From: Amanda Scholes on behalf of Planning.Responses
Sent: 12 March 2018 09:30
To: Planning Scanning
Subject: FW: 12 Raleigh Road

From: Gary Smith [REDACTED]
Sent: 17 February 2018 13:04
To: Mark Jones
Subject: Re: 12 Raleigh Road

Proposed Garage and Utility room. 12 Raleigh Road, Bognor Regis, West Sussex
Proposed Elevations. Drawing Number = 11 Scale 1:100 @ A4

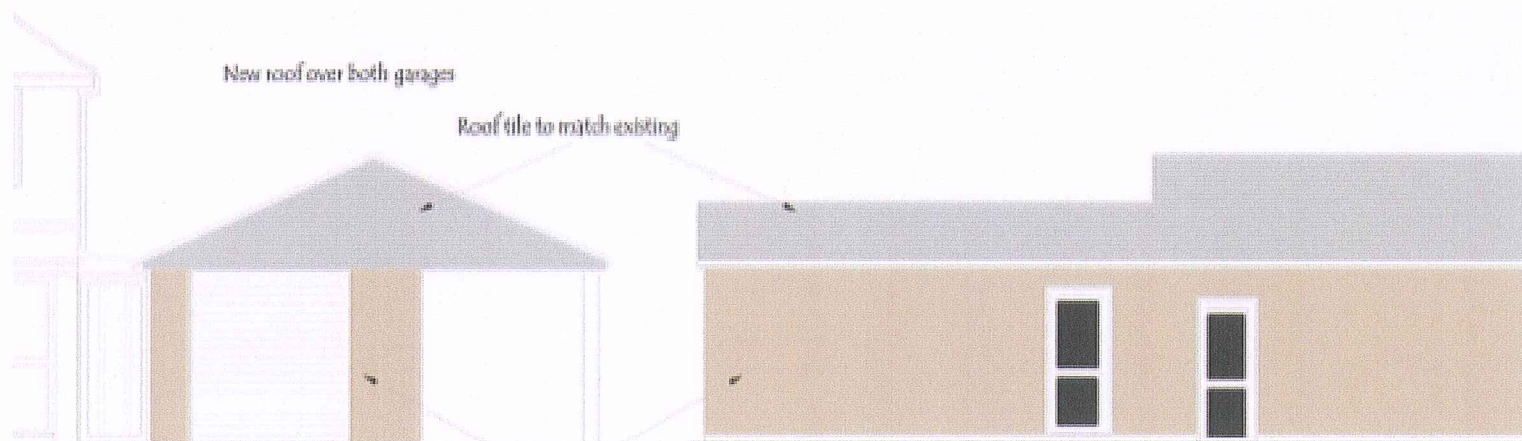
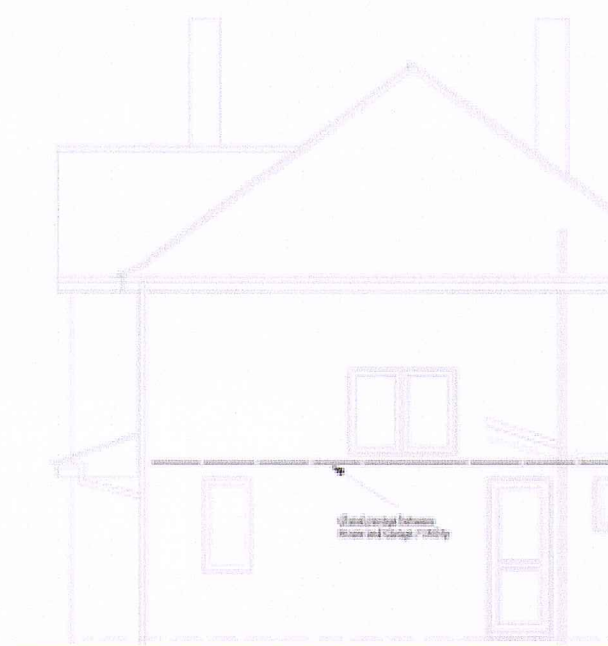
Can you confirm if the new roof over the garage at No.10 is part of the current application.

The roof at no. 10 is currently flat.

We are proposing a pitched roof across both properties in the application to enhance the appearance of both properties.
